Objection re Planning Application FP/121/11:  
'Seacroft', Outram Road, Bognor Regis

Two storey rear extension. Gable extension to front to include 2 balconies. Re-submission following FP/6/11/

Seacroft Outram Road Felpham Bognor Regis

Proposed Rear Elevation

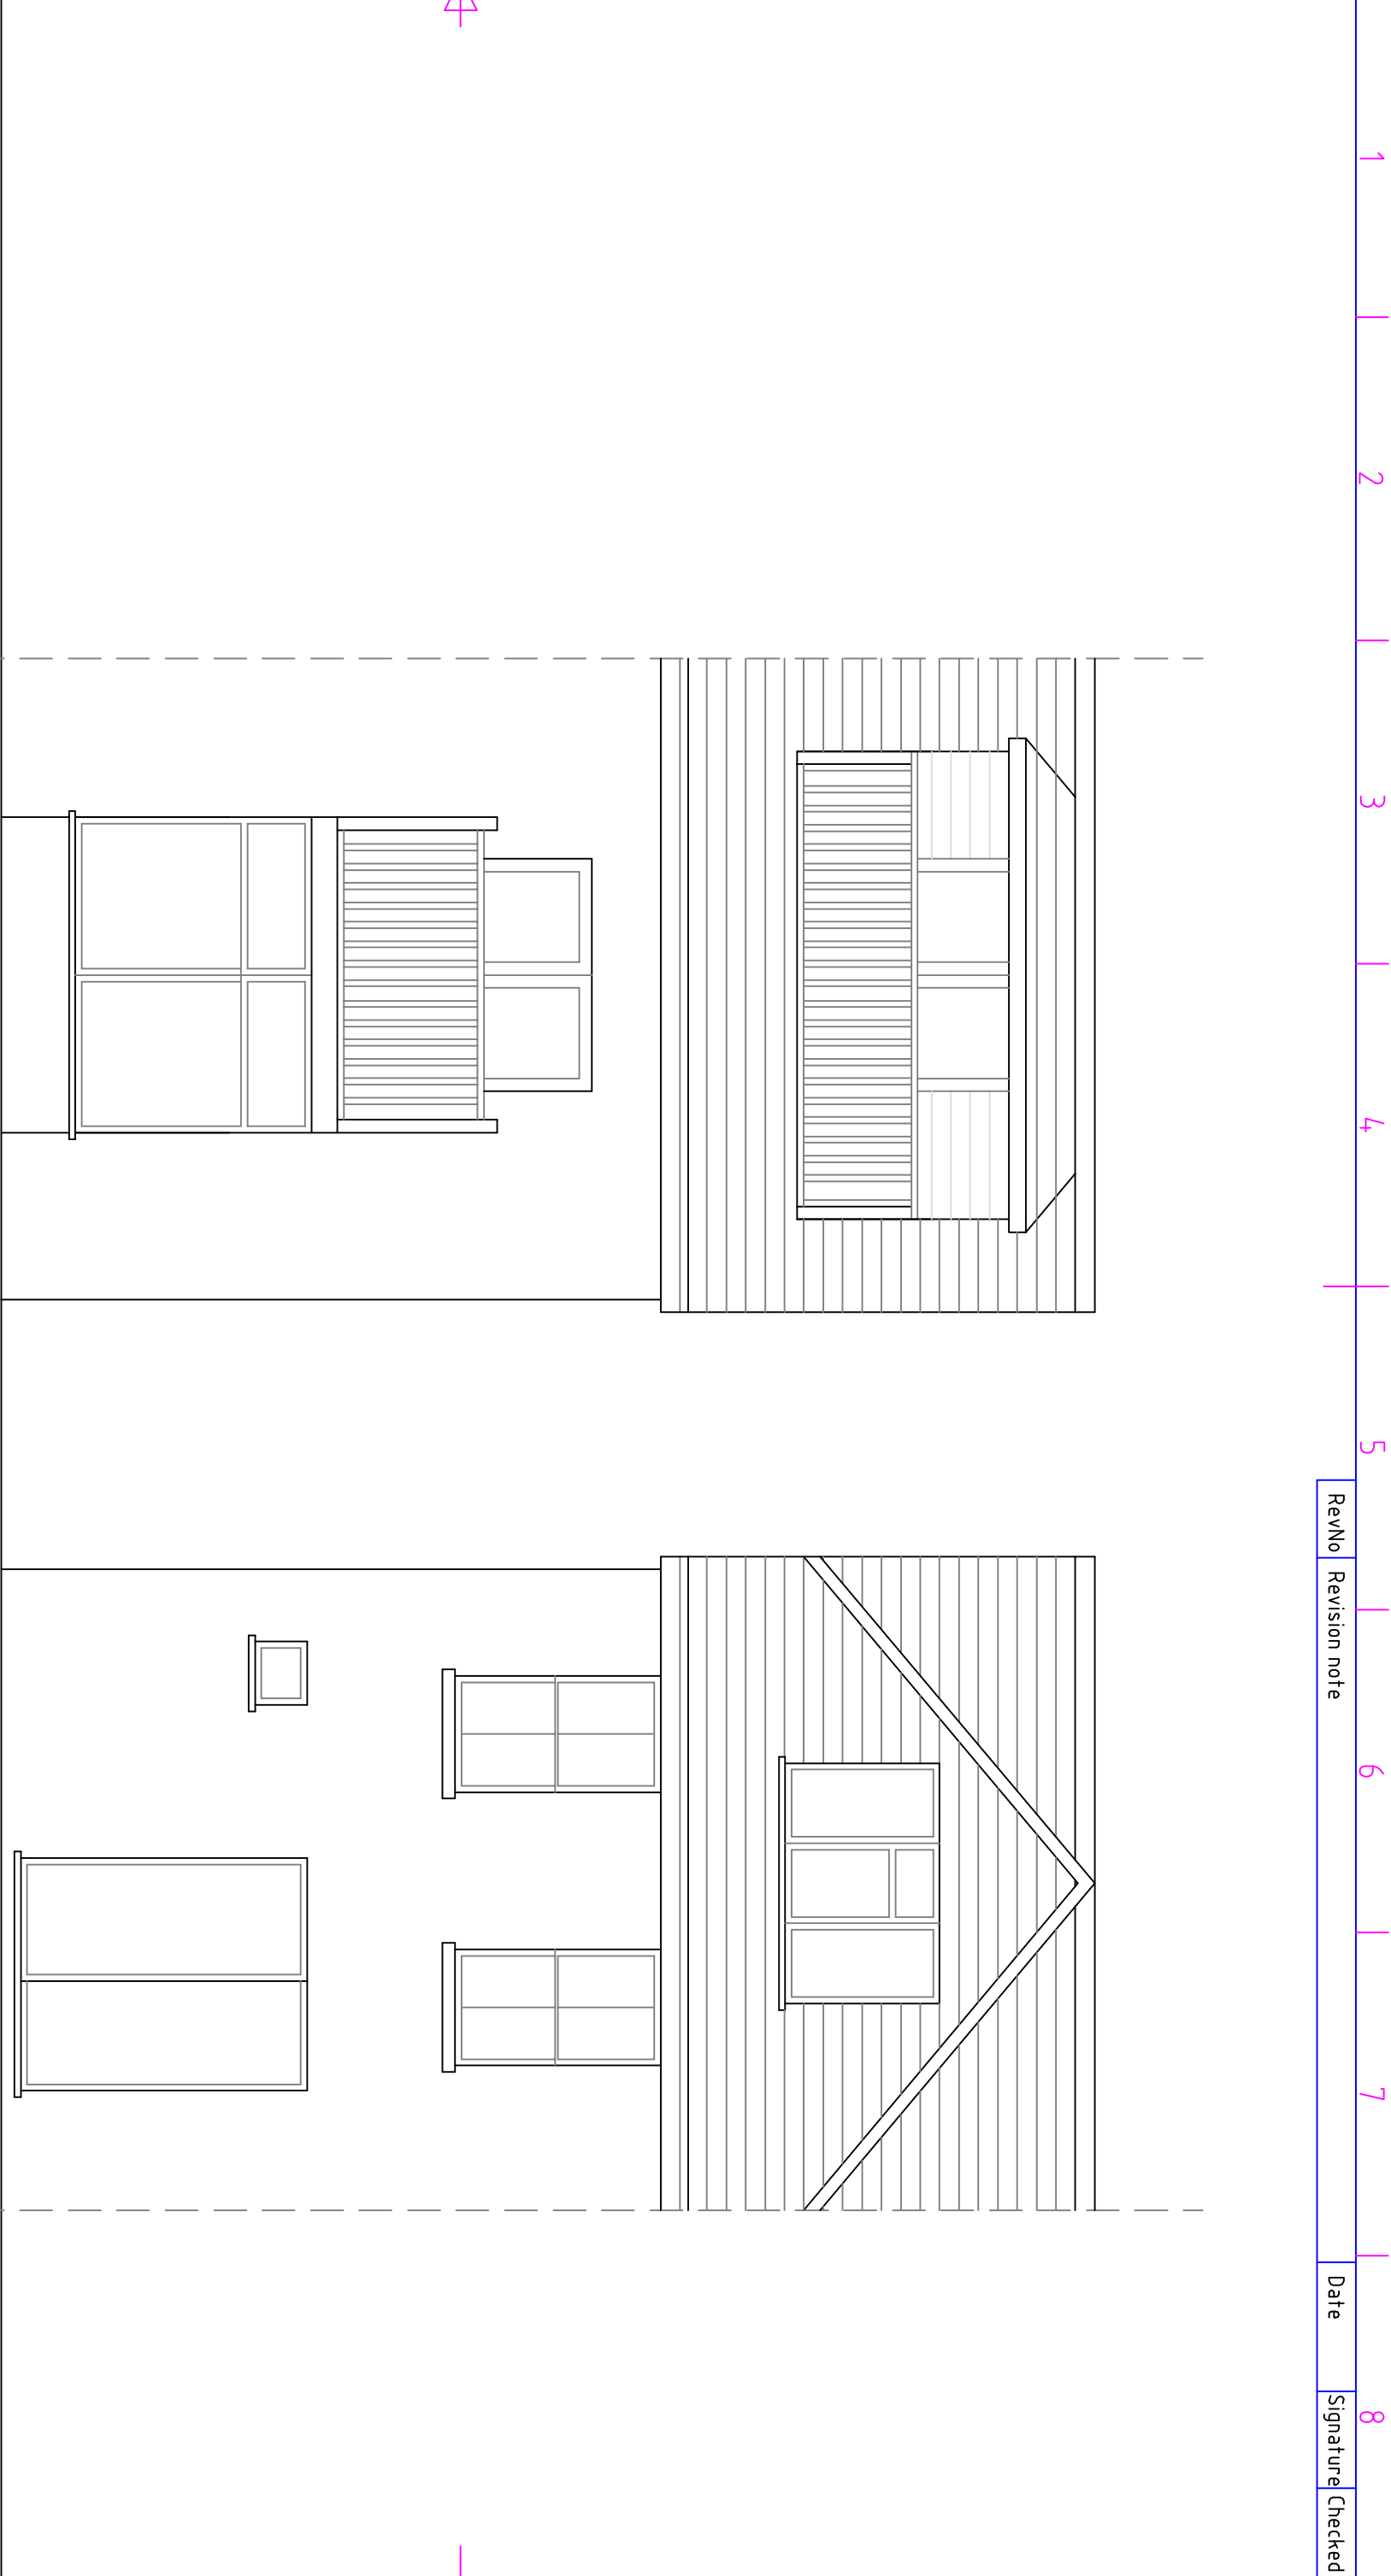
The revised application makes the changes required at the front but leaves the rear totally unchanged.

Arum Council faces a basically unchanged application on the rear of the property

*as the owners of the adjoining property to seacroft in outram road, we would like to object to the proposed plans(FP/121/11) by the applicant mr K Gaughn. The rear extension appears to be an exact replica of the plans that were refused in application FP/6/11. These plans were refused for the following reasons, the proposed two storey rear extension would, by virtue of its size and siting, result in an unacceptable loss of light and outlook to the adjoining residential properties and would have an overbearing impact on those properties to the detriment of the amenities of its occupiers. If those were the reasons for refusal on 06/04/2011 then those reasons should be upheld for this unchanged application. It appears that having been told that his application is un-neighbourly, mr gaughn has given no regard to the adverse impact these plans will have on his neighbours and has resubmitted them with no amendments. The proposed balcony at roof level will make us feel overlooked and is alien to the street scene, also one of the conditions of our own application FP/107/06 which has been passed is that no windows or openings shall be formed in the side elevations of our own rooftop dormers, this is to protect the amenities of adjoining residential properties in accordance with policies DEV1 of the West Sussex structure plan and GEN7, DEV19 of Arun District Local Plan. A balcony at roof level on mr Gaughn's application will not protect our amenities according to the policies of the local plan, ie. DEV1, GEN7 and DEV19. It appears that the applicant has received pre application advice from the planning officer who refused the previous application(FP/6/11), Mrs A Stroud, who is advising that the new application is now satisfactory, but the new application for the rear extension is unchanged from the previous plans that Mrs Stroud refused. If it was refused before and remains unchanged it should be refused on the same grounds.*

Proposed Side Elevation

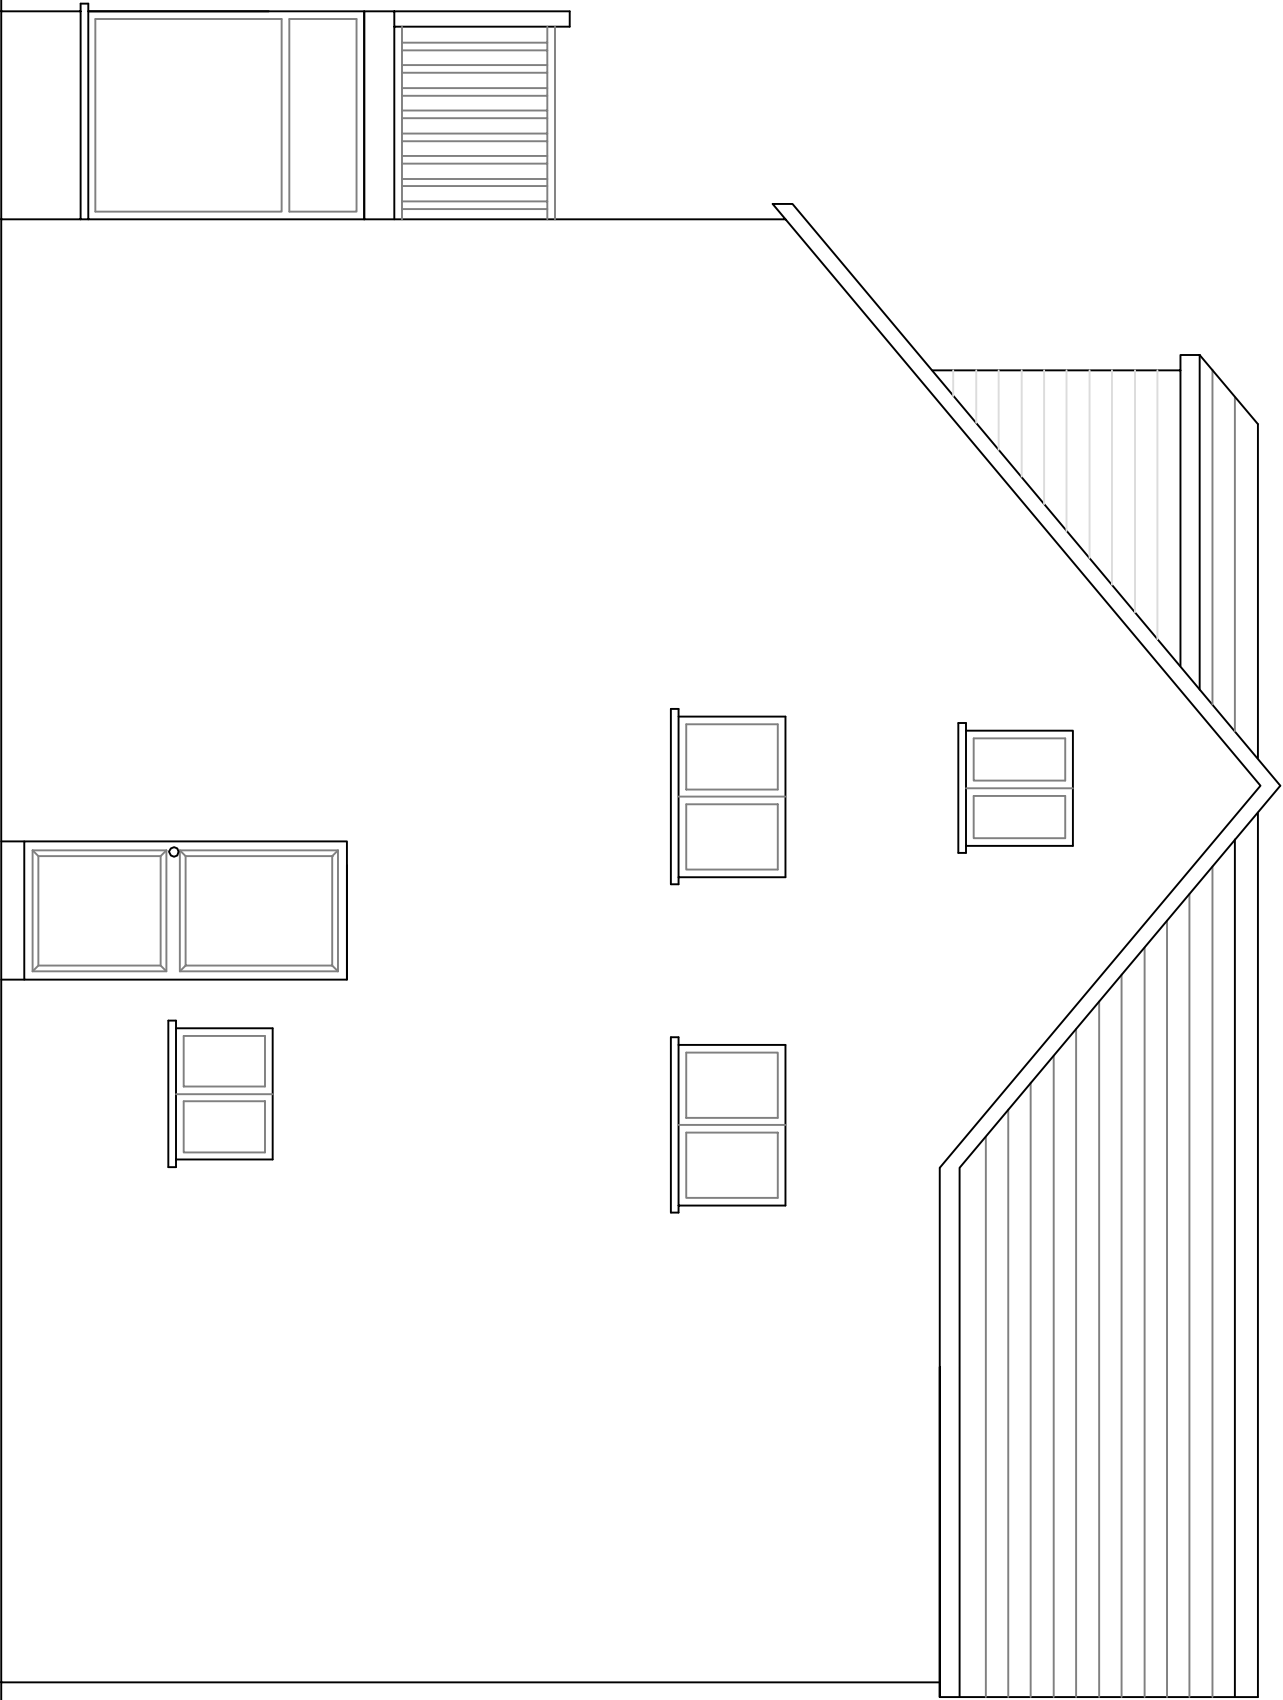
The side wall elevation of the proposed additions matched against the existing size shows clearly this almost doubling of the building. At the rear if the upper roof extension was lowered to be flat and so only a little higher than the existing extension to the neighbouring semi detached house this would be a possible compromise. Sadly Kevin Gaughin did not discuss with my next door neighbour and me his plans. I am sympathetic to him seeking extra room for his family, but what is proposed is on a scale which is breathtaking and shows a total disregard for the impact on everyone else.
